November 12, 2015

Re: 59 Washington Avenue- 013 I04301A – Sign Permit for Roustabout Restaurant- Permit #2015-02556

SHEET TITLE	IST FL
FIRST FLOOR VERTICAL BOUNDARY	
DATE	03/14
SCALE	1/8" = 1'-0"
PROJECT NO.	18813
OWNER	A&M PARTNERS, LLC
DESIGNER	TURGEON ARCHITECTS
DATE	03/14

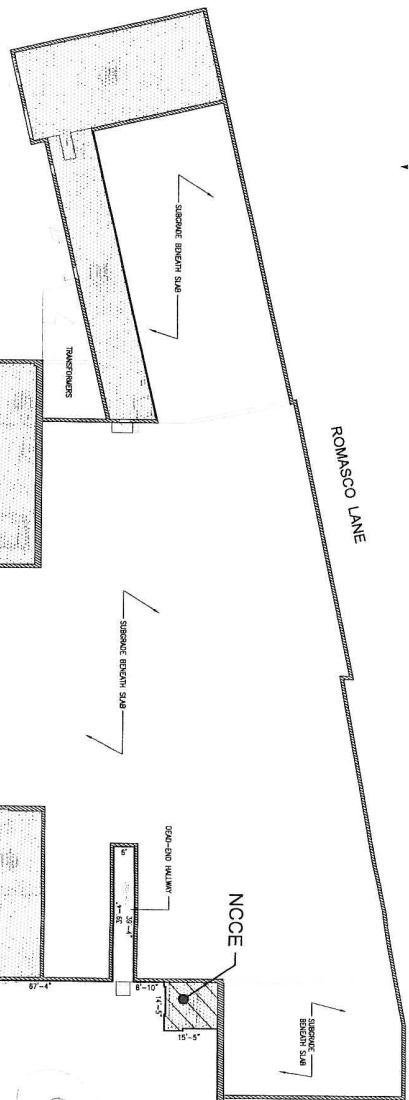
Staff Comment: This standard states the sign “shall be appropriate to the scale and character of the neighborhood in which it is located and shall be designed to suit the conditions from which it will be viewed”. As mentioned before, there are no existing building signs on most of the businesses in the vicinity of this property. This is a high traffic area and the blade sign is more visible than the proposed building sign. There are wayfinding blade signs on the structure to enhance visibility for vehicle traffic.

Staff Comment: There are no unique circumstances or characteristics that are associated with the property. The property does have existing signs that are visible from the main street on either direction.

Thus, the request for a sign exception at 59 Washington Avenue is denied.
